## **OXFORDSHIRE COUNTY COUNCIL'S RESPONSE TO CONSULTATION ON THE FOLLOWING DEVELOPMENT PROPOSAL**

**Application no:** 24/00380/REM

**Proposal:** Reserved Matters application for appearance, landscaping, layout and scale pursuant to outline permission 23/01941/F for a mixed-use HQ building (Classes E(g), B2 and B8)

**Location:** The Innovation Quarter , Bicester Heritage, Skimmingdish Lane, Launton

Client
Bicester Motion Limited
 Project
BM_IQ_SPY
 Title
Proposed Ground Floor

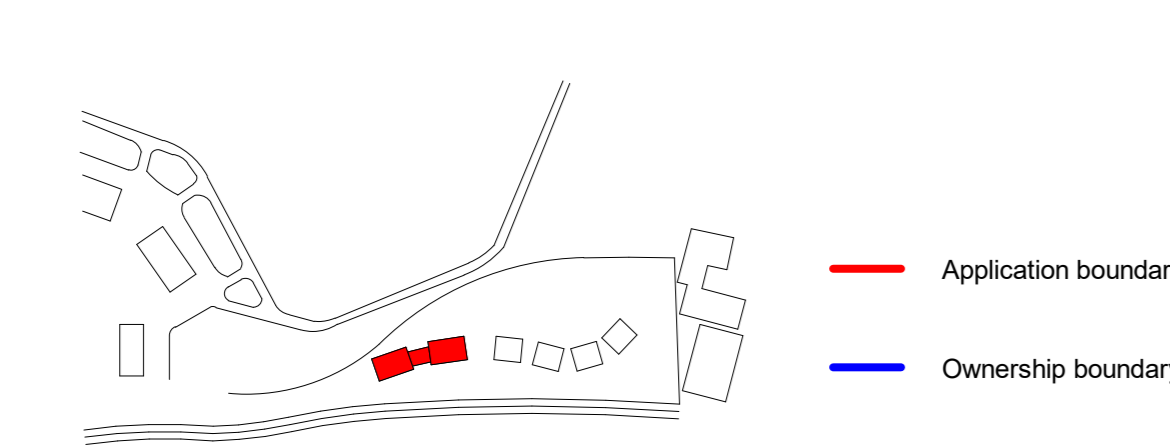
The number of car parking spaces shown accords with OCC's adopted car parking standards for the breakdown of floor area proposed. The layout of the car parking spaces and of the servicing area appears to be appropriate.

Cycle parking is largely located in shelters within the car parking area, albeit in close proximity to the main entrances to the buildings and to zebra-style crossings over the access road. It appears that the cycle parking would be accommodated through the use of Sheffield stands and this is the preferred approach, this should however be clarified. There are also a smaller number of Sheffield stands located adjacent to each building, which is welcomed.

Pedestrian access appears to be mainly from the northern side of the buildings, as there is no footway along the access road along the southern side. However, a footway or separate path alongside the access road and through the parking areas south of the buildings should be considered.
